Your ref:
Our ref: 21/00527/F
Please ask for: Mrs Lesley Raby
Direct dial: 01553 616818
Direct fax: 01553 616652
E-mail: borough.planning@west-norfolk.gov.uk

Details: **Two storey extension to side of dwelling at Whitecross Green Lane Walsoken Norfolk PE14 7BJ**

I have received a planning application as detailed above but cannot process it until I receive some more information:

EXISTING SIDE ELEVATION (SOUTH)
1:100

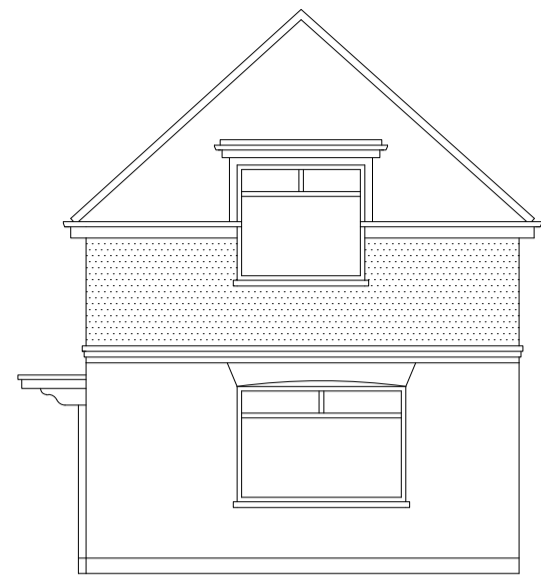
1. As the property lies within an area at risk to flooding, please complete the simplified Matrix and return it. The Matrix can be found at https://www.west-norfolk.gov.uk/info/20173/information_for_planning_agents/231/flood_risk_information
2. The existing floor plan shows a window to the lounge diner but the elevation shows a door to the South. Please amend.
